Our Case Number: ACP-323830-25

**An
Coimisiún
Pleanála**

Re: Proposed flood relief scheme
in Mountmellick, County Laois

Drawing No. :	19105-JBB-XX-XX-DR-C-02761	Revision	C01	Suitability Code	A1
---------------	----------------------------	----------	-----	------------------	----

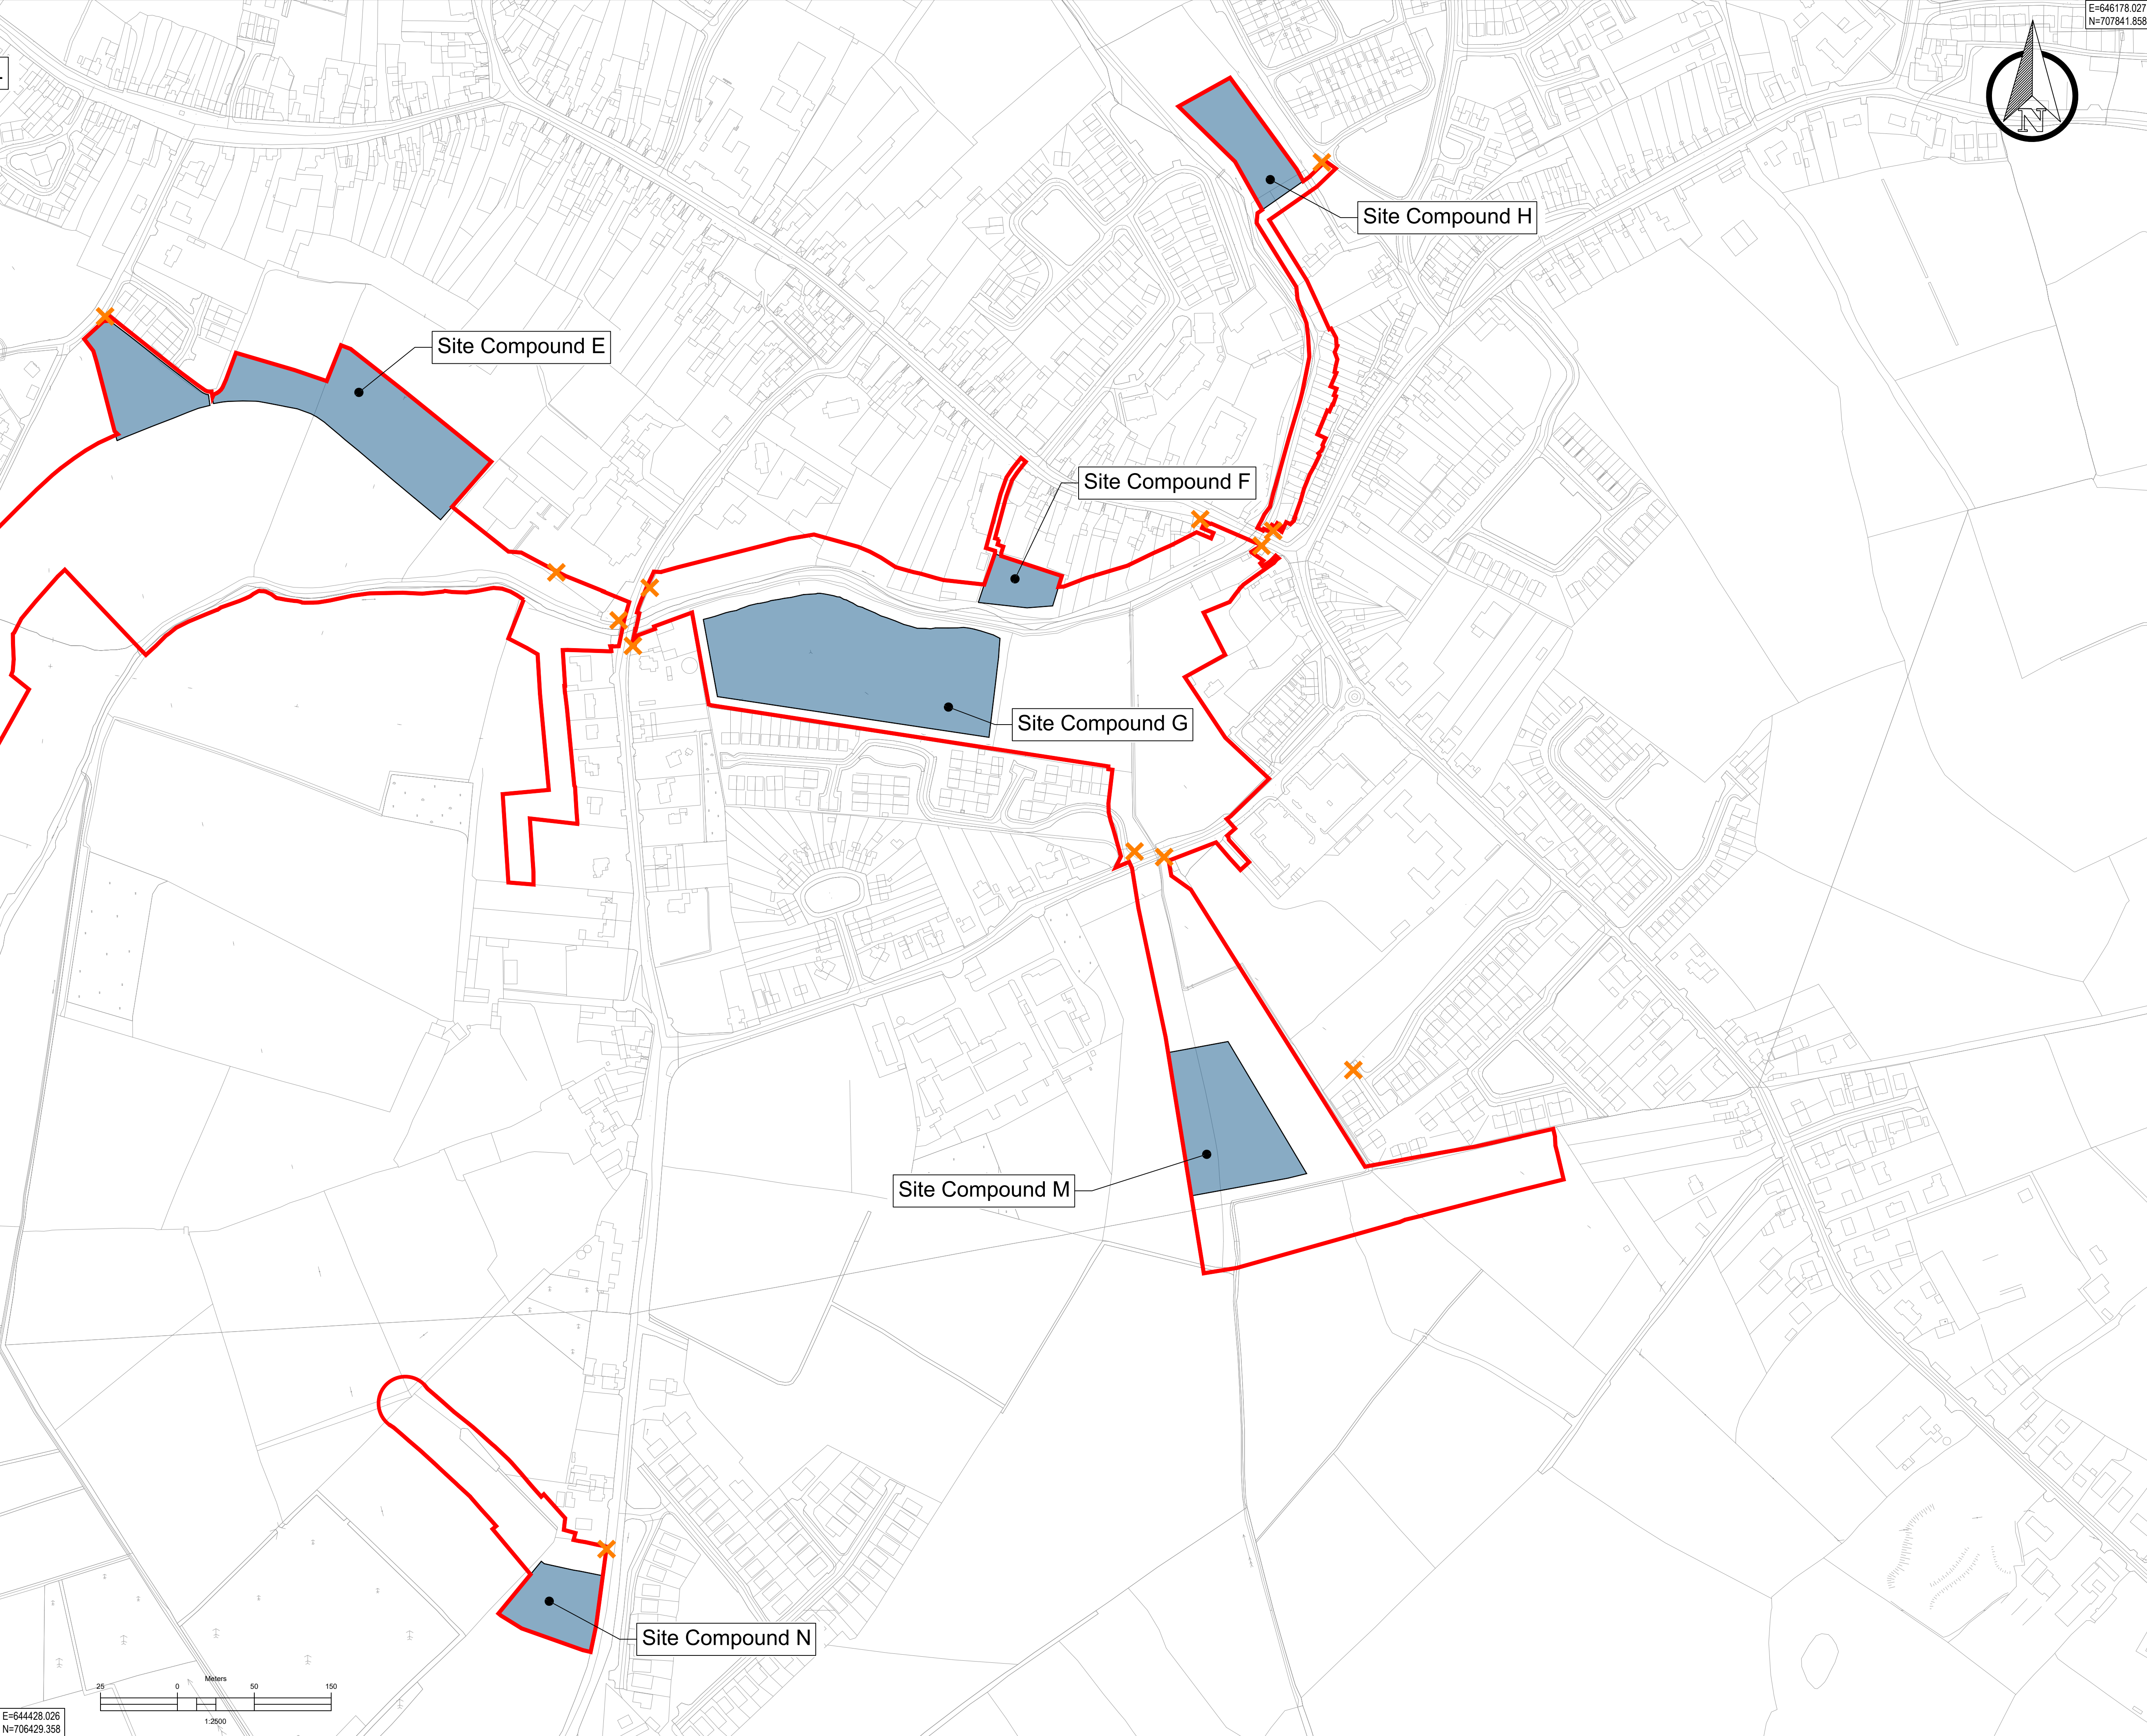
- 5) Reference is made to 16 temporary construction compounds in the Environmental Impact Assessment Report (volume II) accompanying the application, however, 14 temporary compounds are identified on the application drawings (nos. 19105-JBB-XX-XX-DR-C-02760, 19105-JBB-XX-XX-DR-C-02761 and 19105-JBB-XX-XX-DR-C-02762). The applicant should clarify the number and locations of temporary construction compounds proposed for the project.
